ORAN PARK HIGH SCHOOL AND ORAN PARK PUBLIC SCHOOL

State Significant Development (SSD 16_7968)

Response to Submissions

Date: 6th September 2017

Figure 5 – Proposed Bus Zone and Drop Off Areas

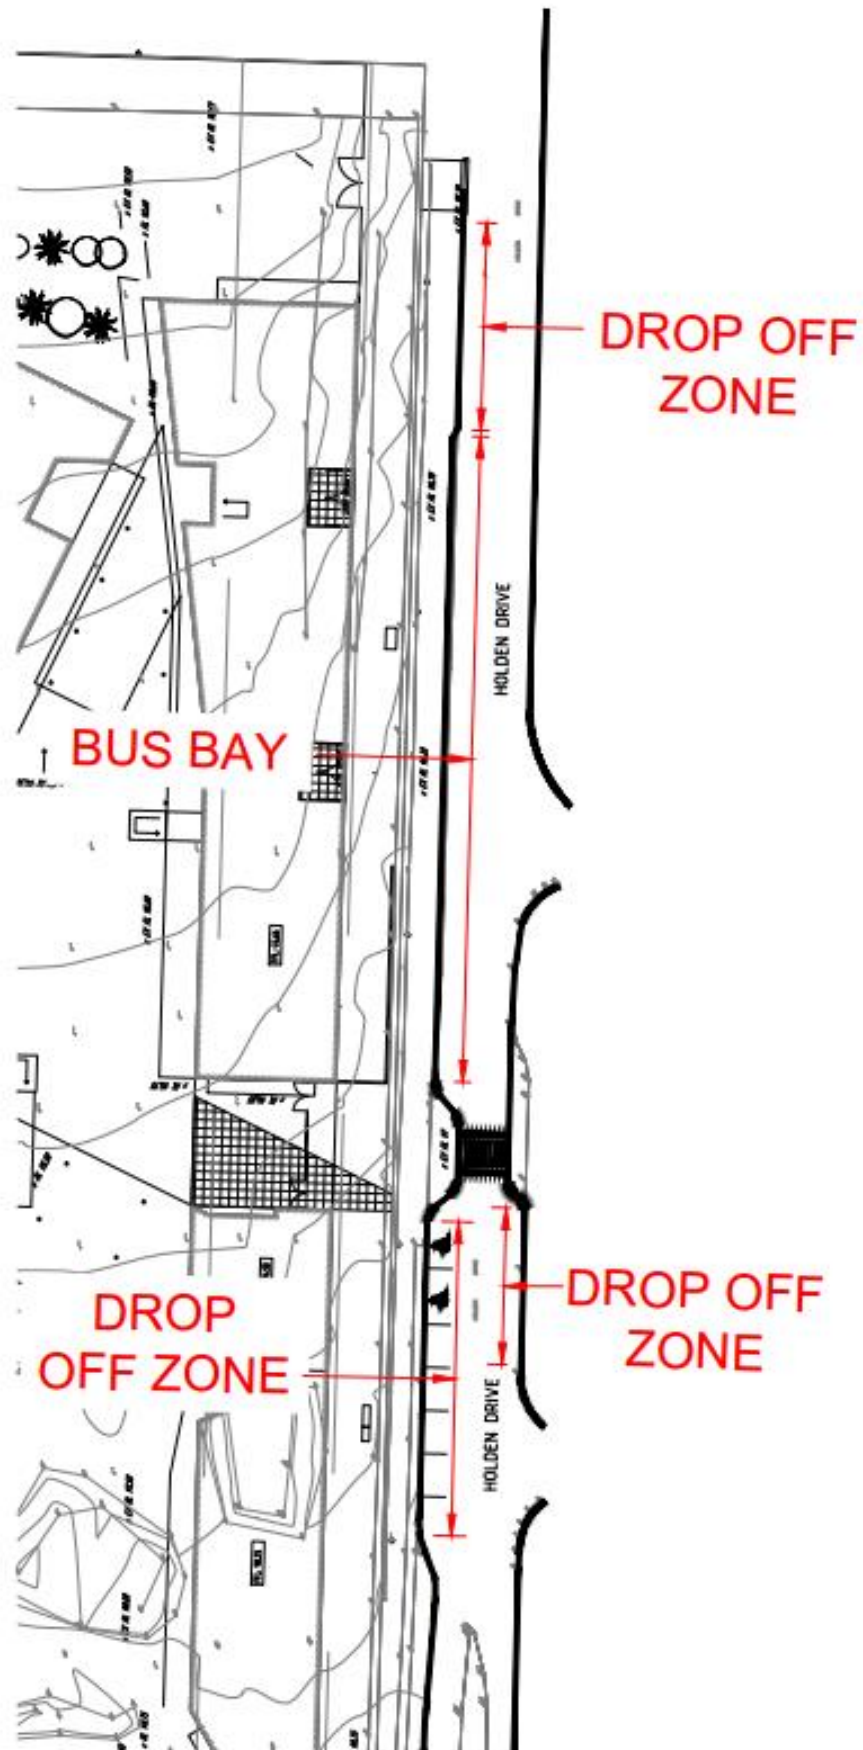
2.04	<i>Relocation of Bus Bays</i> Consideration should be given to relocating the bus bays and the provision of access ways to the Dick Johnson Drive frontage for the following reasons: • The 3 bus spaces proposed on Holden Drive will not accommodate the 15 buses required without adversely impacting the road network. • An indented bus bay could be provided along Dick Johnson Drive which could accommodate a greater number of buses. Camden High School which is currently just over half the size of this proposal has a bus bay length that can accommodate 8 buses. Even at this length buses, particularly in the afternoon, have to queue on the road in order to wait to access the bus bay.	Dick Johnson Dr is designed as a four (4) lane collector road, joining The Northern Road to the Oran Park Town Centre. Relocation of the bus bays would require indenting the school boundary and would: - require relocation of the existing bio-retention basis; - compromise the sports field and open space provision; and - require the construction of extensive retaining walls Also, from an operational perspective, it's the consensus of the Project Reference Group that bus bays in this location would be too remote from the main entrance to the school.

2.05.02 The drop off zones proposed are considered inadequate and will not accommodate the proposed 400 vehicle drop off in the AM peak.	Drop-off zone has been increased to accommodate 14 vehicles and is sufficient to accommodate the anticipated drop-off in the AM peak. Please refer to the attached: - Drawing P1 Holden Drive Layout prepared by Woolacotts Consulting Engineers; and - Updated Traffic Report (Section 3.3) prepared by Woolacotts Consulting Engineers.

The proposed layout for Holden Drive has been updated to improve traffic flow, including 100m of Bus Zone, sufficient for at least four (4) buses at once. Please refer to the attached: - Drawing P1 Holden Drive Layout prepared by Woolacotts Consulting Engineers; and - Updated Traffic Report (Section 3.2) prepared by Woolacotts Consulting Engineers.
